CITY OF ALBUQUERQUE

May 23, 2024

**Re: Cuba Botanicals LLC Grow Facility
5904 Florence NE, Albuquerque, NM 87113
Traffic Circulation Layout
Engineer's/Architect's Stamp 5/22/2024 (B18D030)**

PROJECT INFORMATION

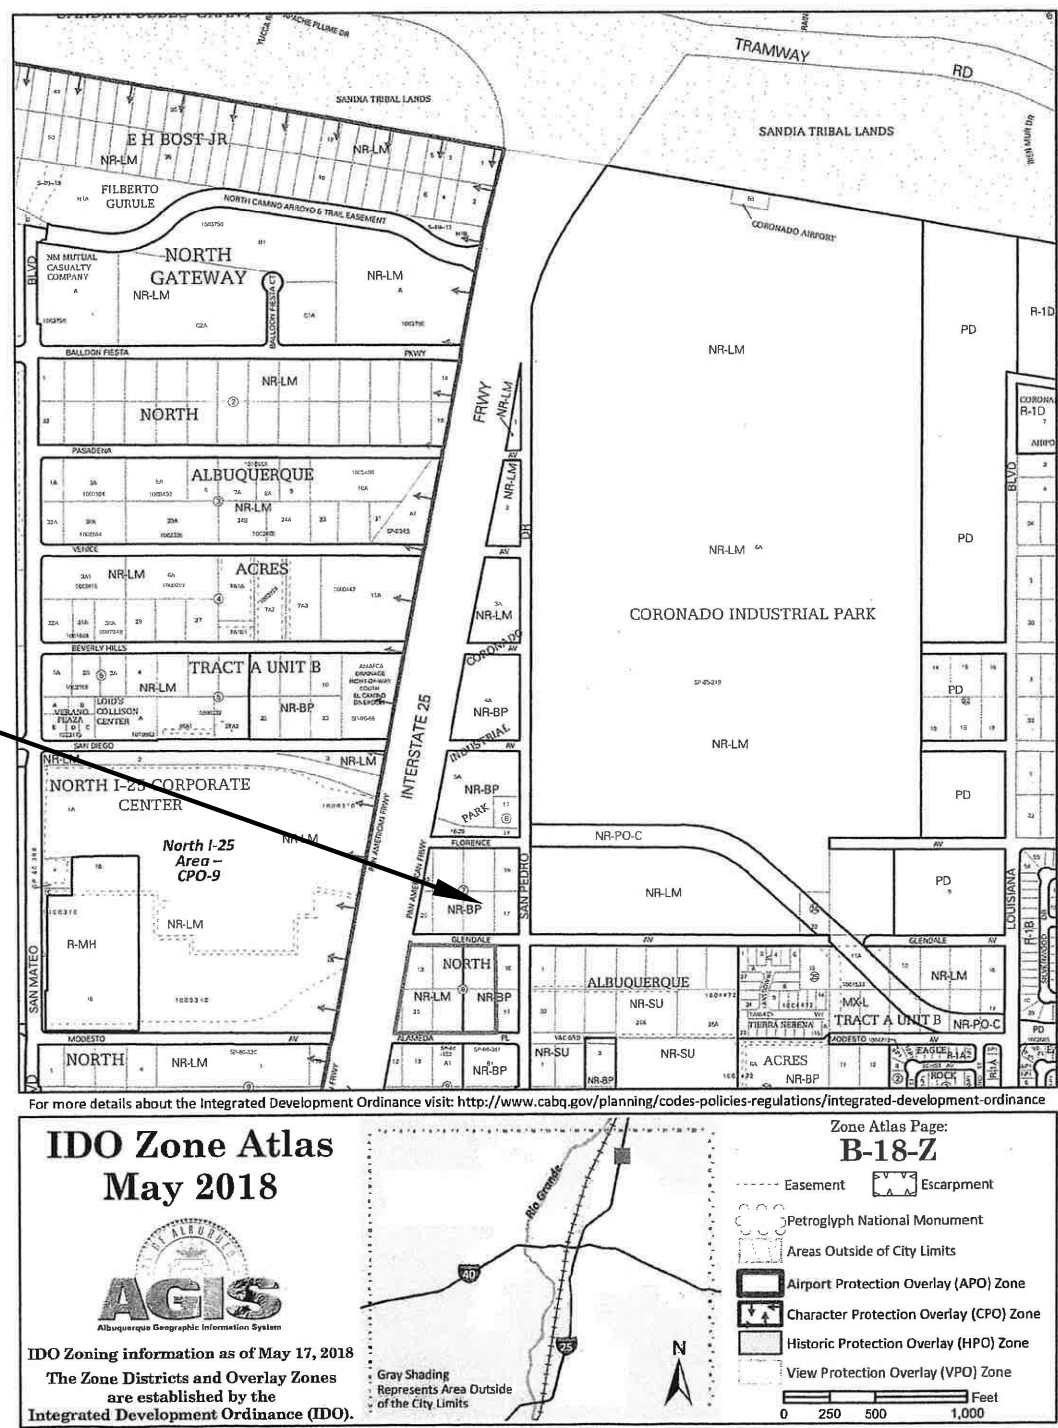
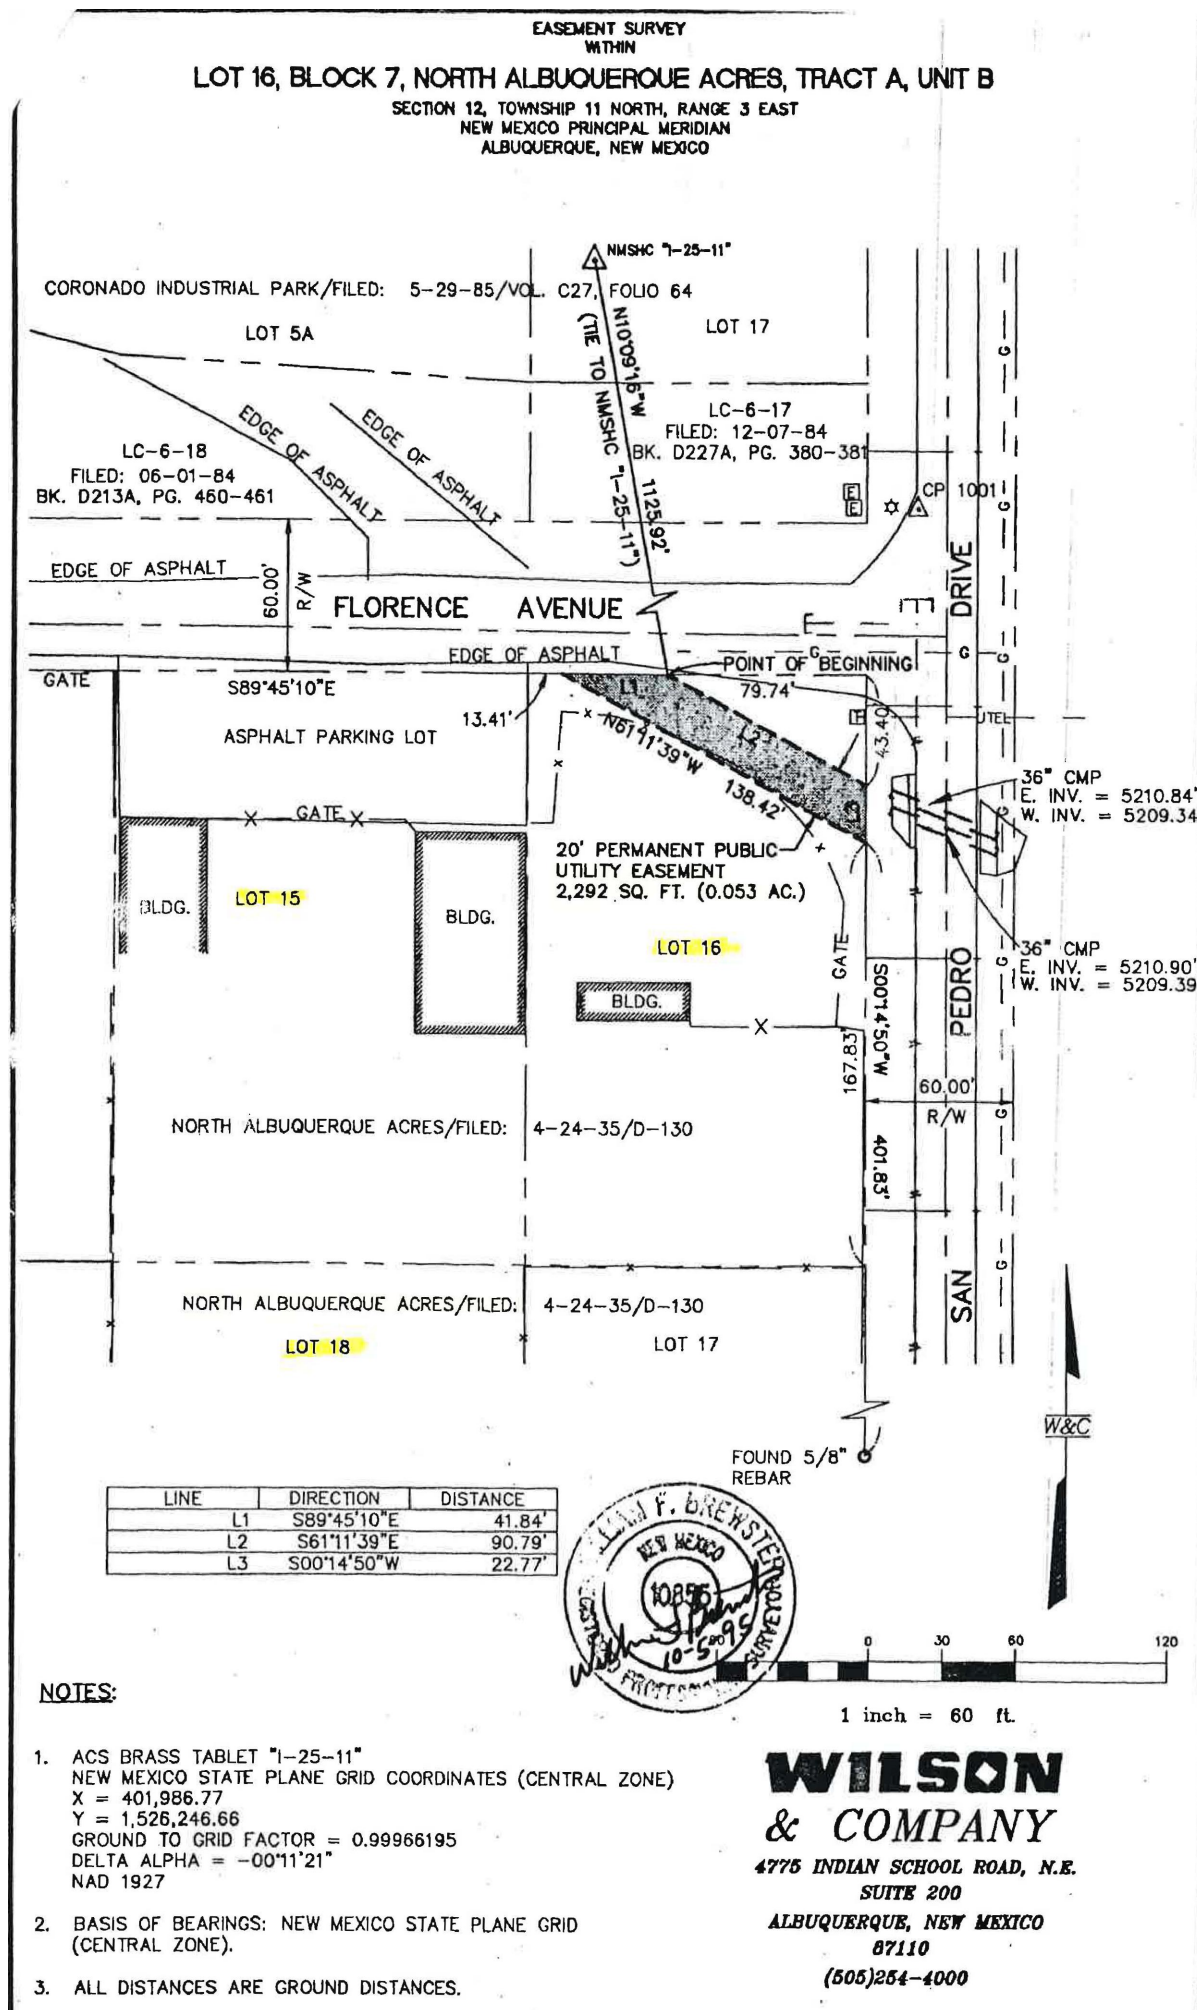
1. Correct the address shown on the general info.

**Property Address: 5409 Florence A
Albuquerque, N
87113**

2. A minimum Three Bicycle spaces are required, or two Bike racks

**Space / 1,000 Sq. ft. GFA
Parking Spaces and 1 HC Requ
1 Bicycle rack will be installed
Main Entrance: Florence Ave.**

5. Add another Bike rack
